February 28, 2020

Timberland

9027 SE 60<sup>th</sup>. ST.

2001-170

LATERAL & GRAVITY DESIGN
KLRY PLANS

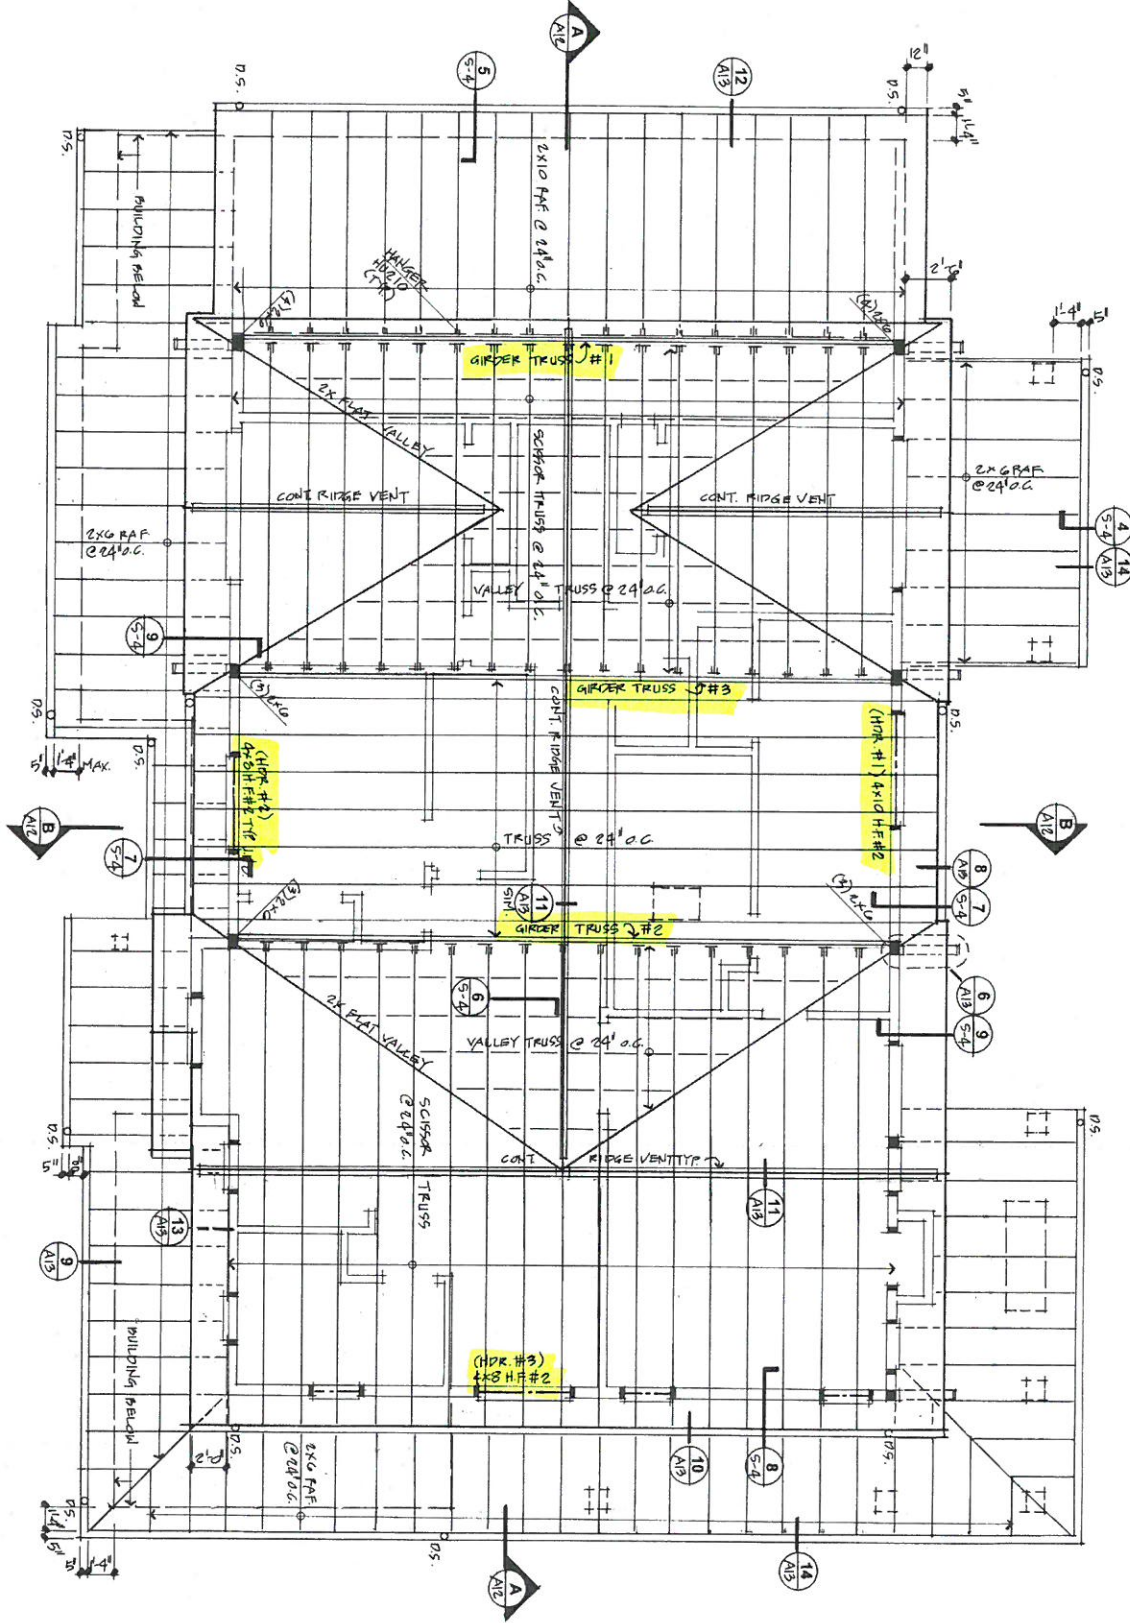
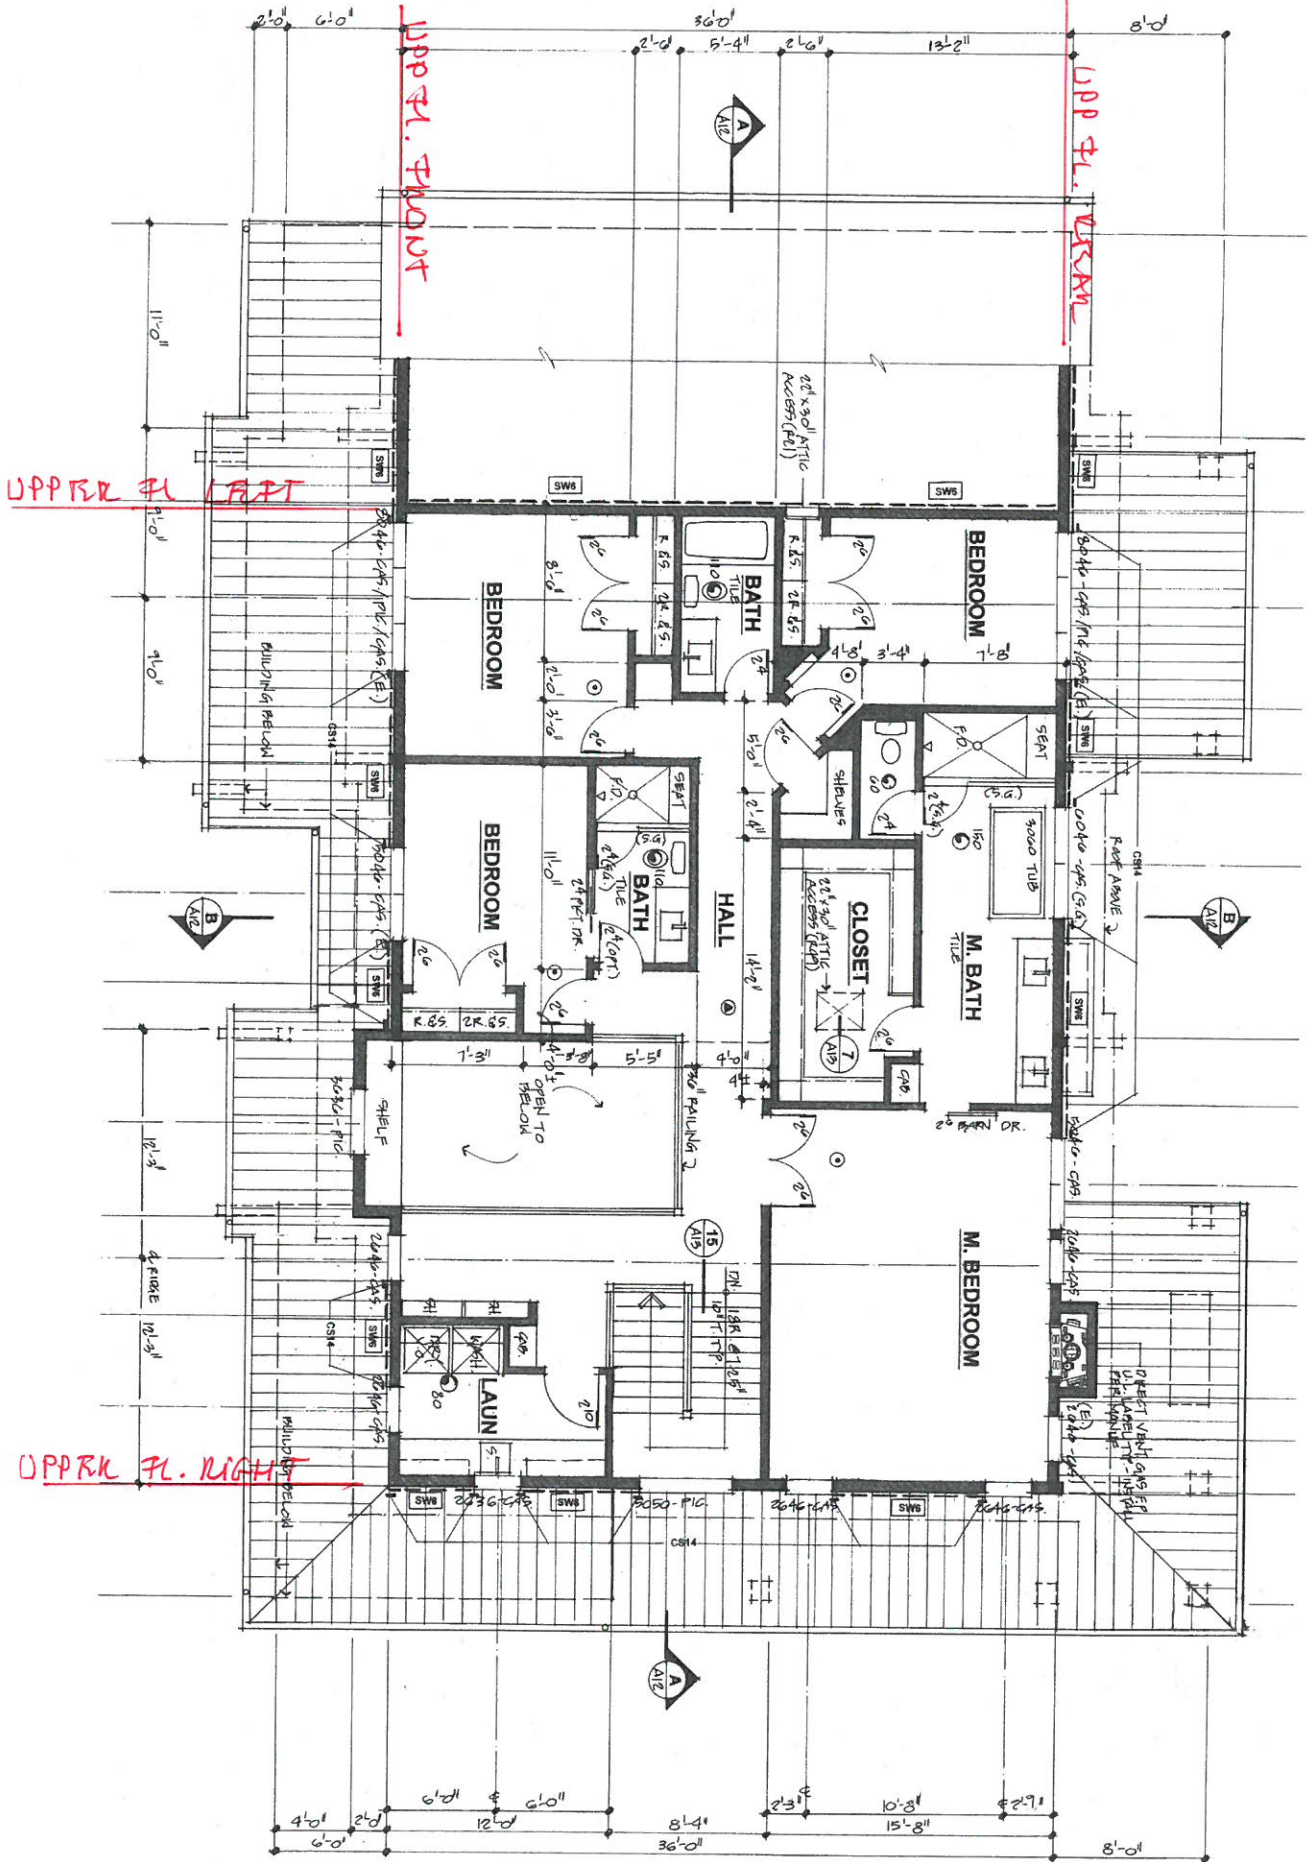
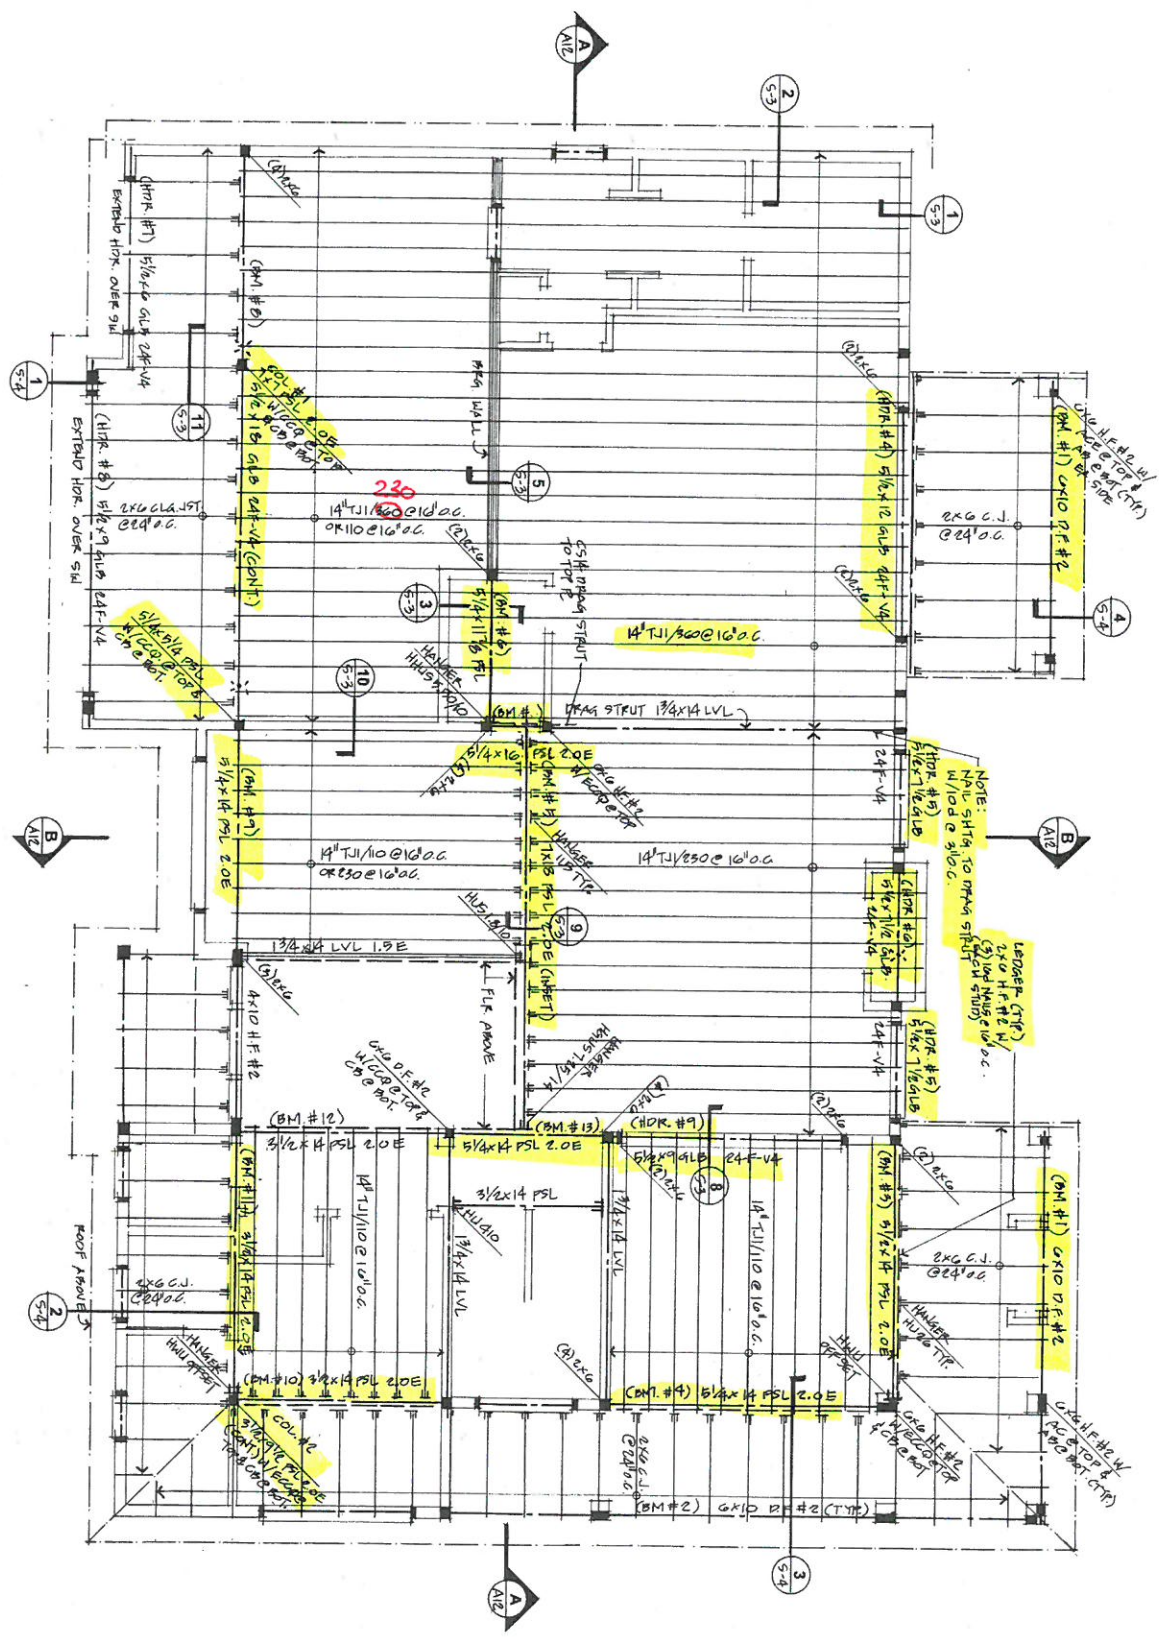
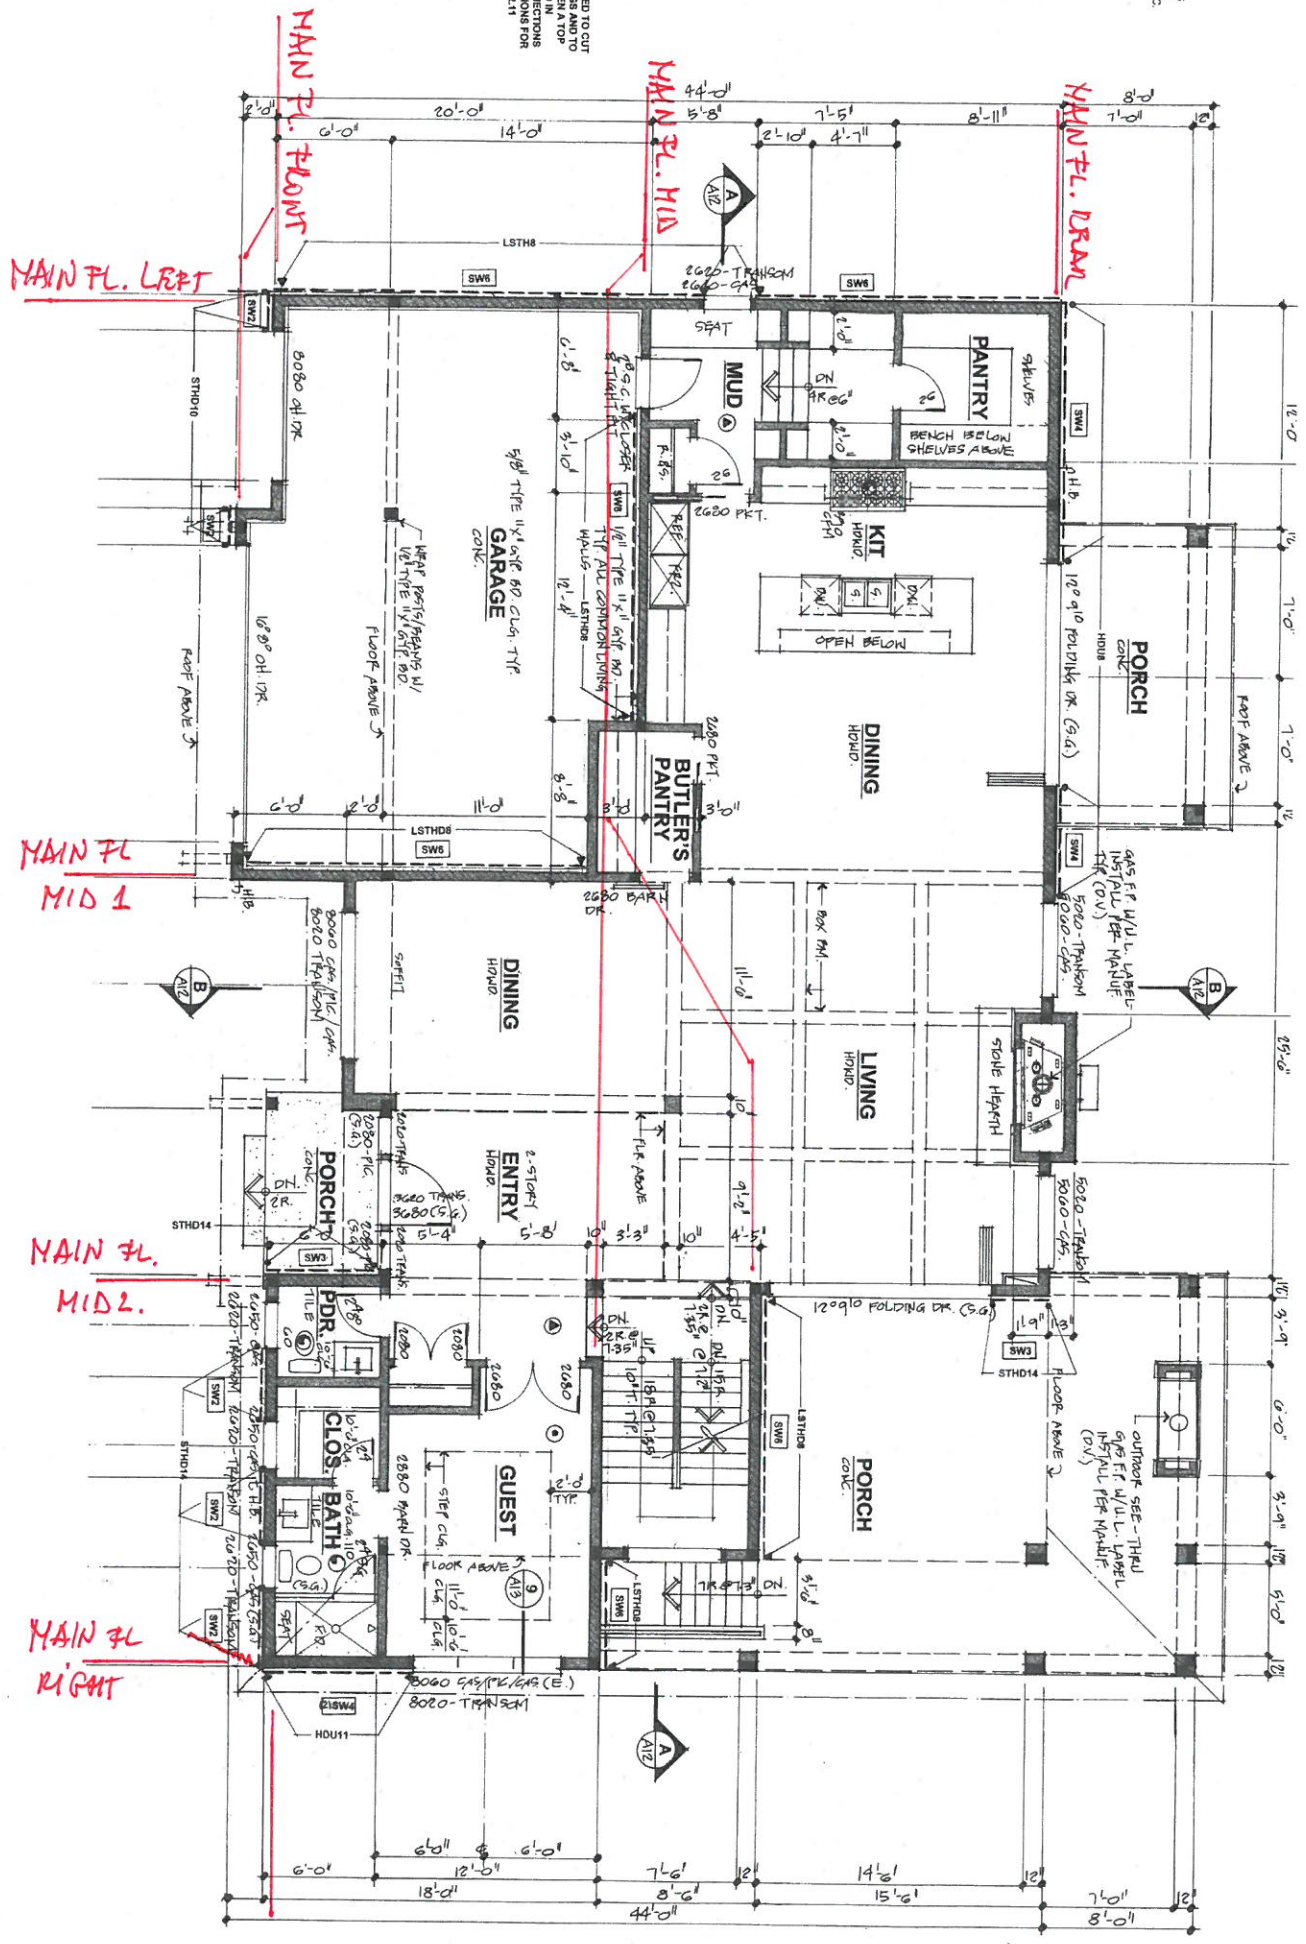
Key plans are already provided on structural calculation sheets page 5-10, attached separate as well.
